Submission to SSD Application - SSD-32489140

This submission has been prepared in response to the State Significant Development Application (SSD 32489140) for the Ascent Logistics Centre at 520 Gardeners Road, Alexandria (the site).

C ELEVATION EAST
DA-010/ 1: 300

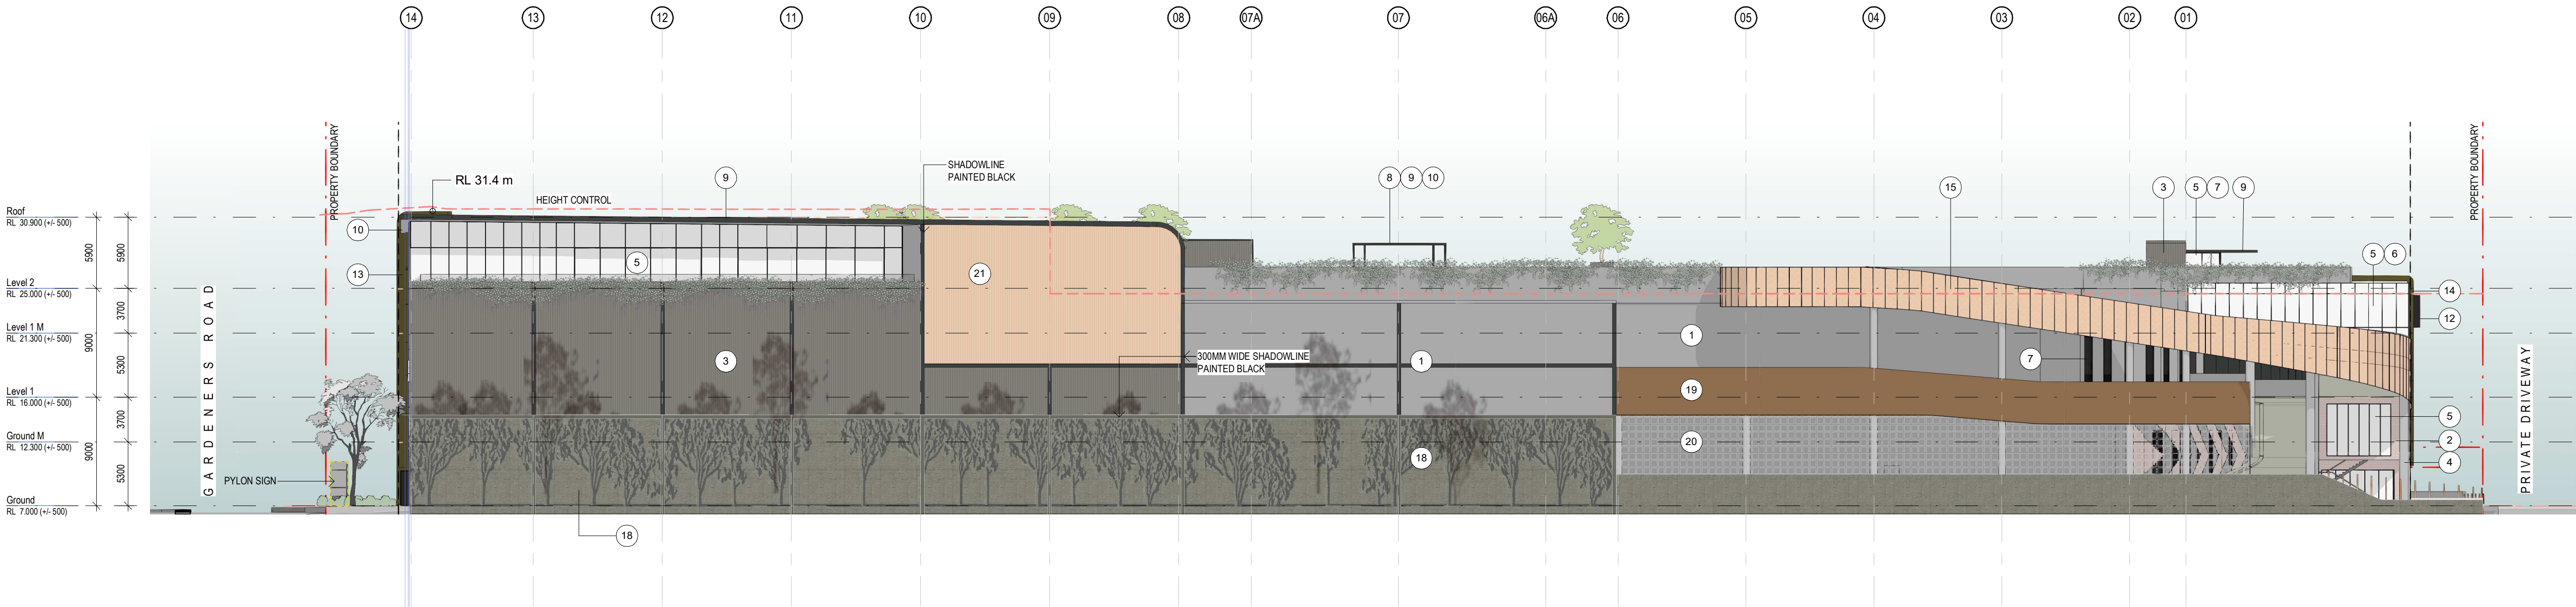
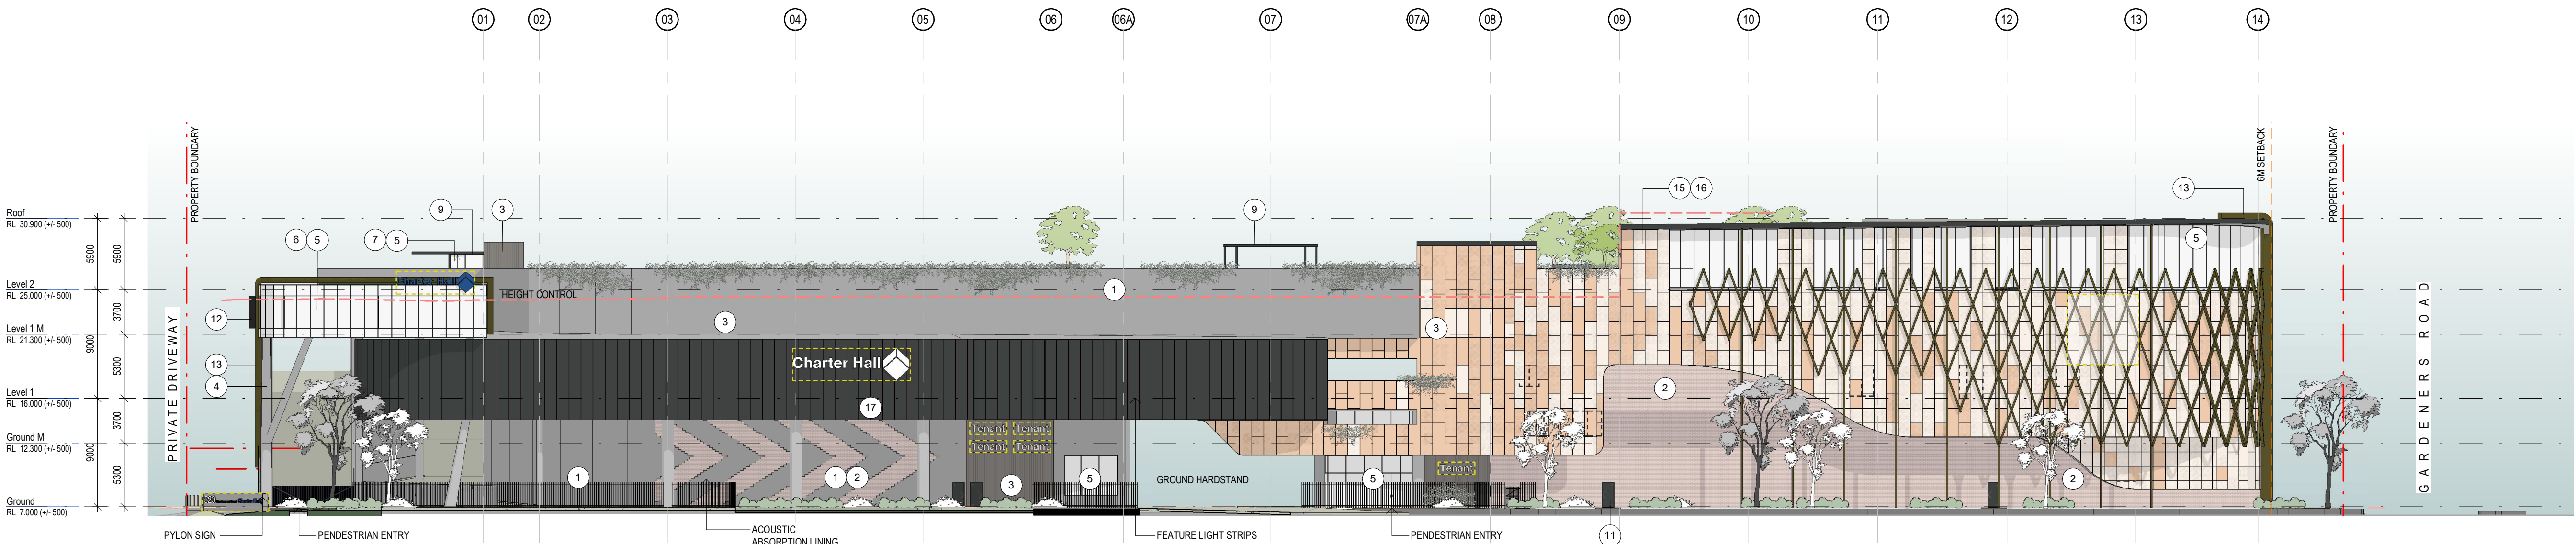
The proposed setback along the northern frontage of the site, along the adjoining private driveway, of 4 m does not comply with the 6 m requirement as set out in Section 5.8.2.2. of the Sydney Development Control Plan (SDCP) 2012. Additionally, a minor non-compliance of the 6 m setback is provided on the upper levels on the western boundary of the site, fronting Bourke Road.

The large vehicle crossover on Bourke Road does not provide refuge or seek to reduce the width of the hardstand to ensure safe and equitable passage for pedestrians travelling to and from Mascot Trains Station on Bourke Road.

DEEP SOIL 1644.75 m²
PERMIABLE 1356.61 m²
TOTAL AREA OF DEEP SOIL 3001.36 m²

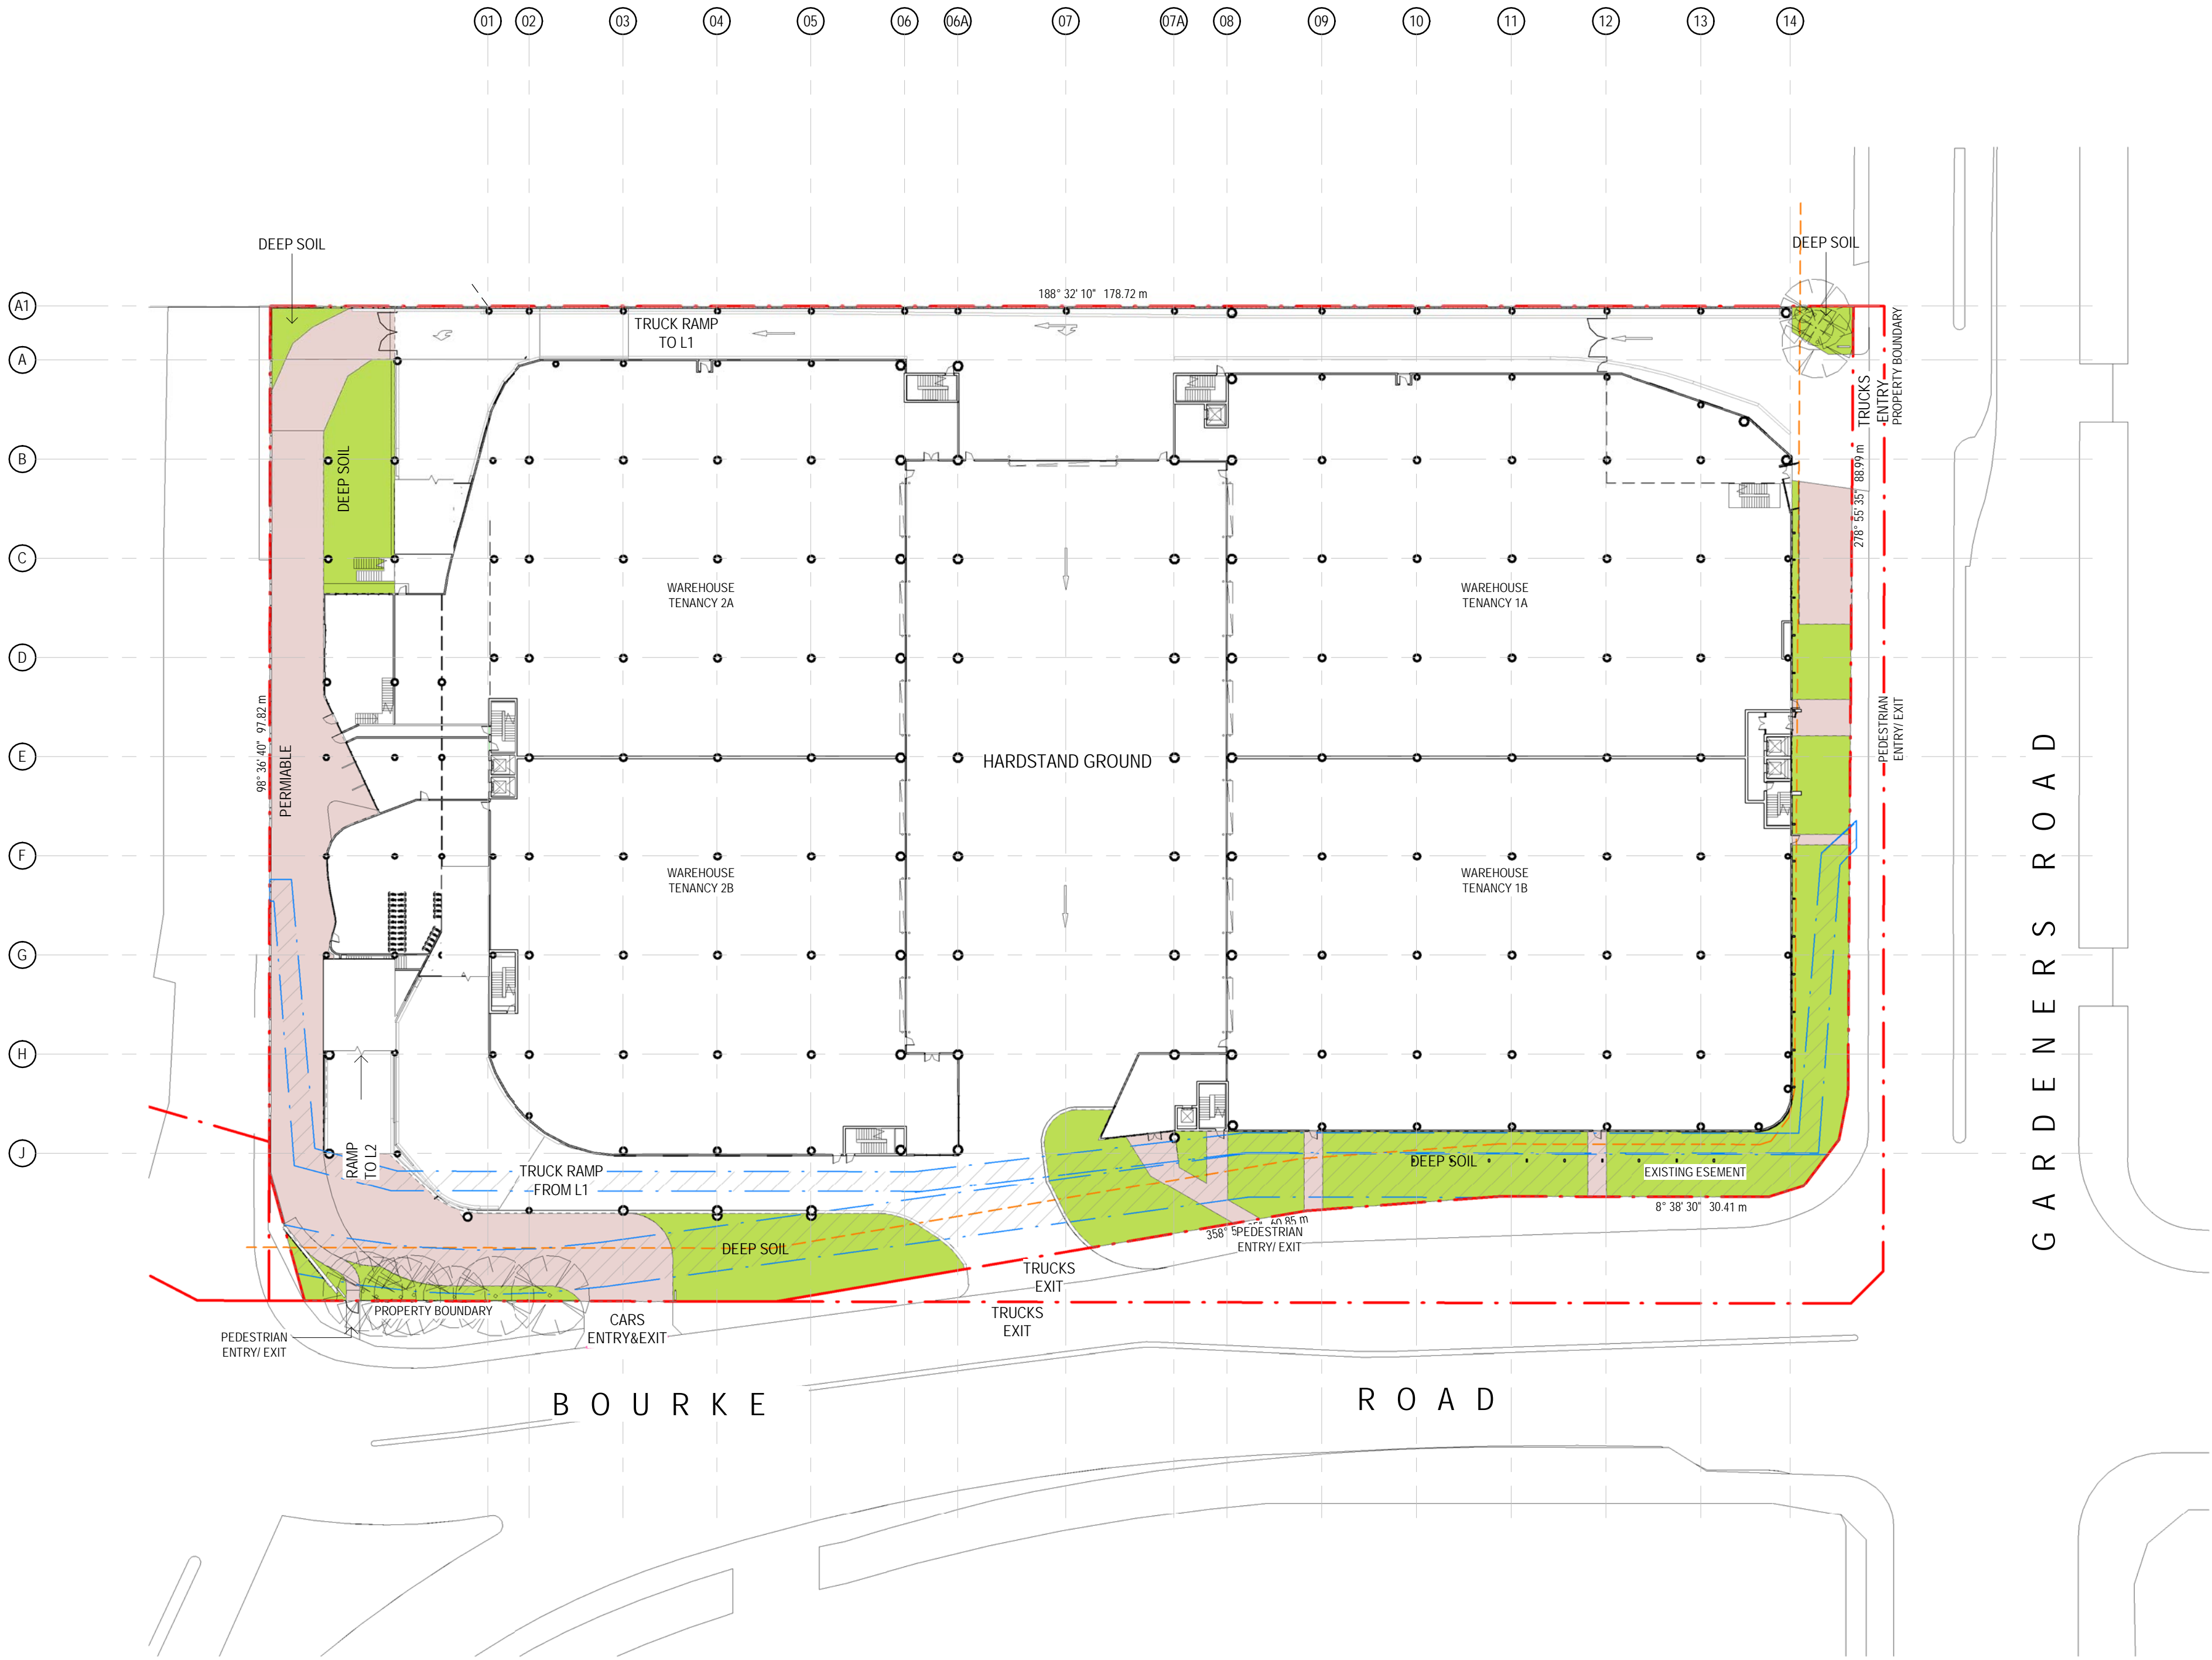
Clarification is required to determine the total area of the deep soil zone. The proposal states the deep soil area within the site is 2,911 m² (15.3% of total site area).

The proposed deep soil zone calculations include permeable surfaces, signage structures, services and hardstand areas such as the pedestrian paths and vehicular entries.
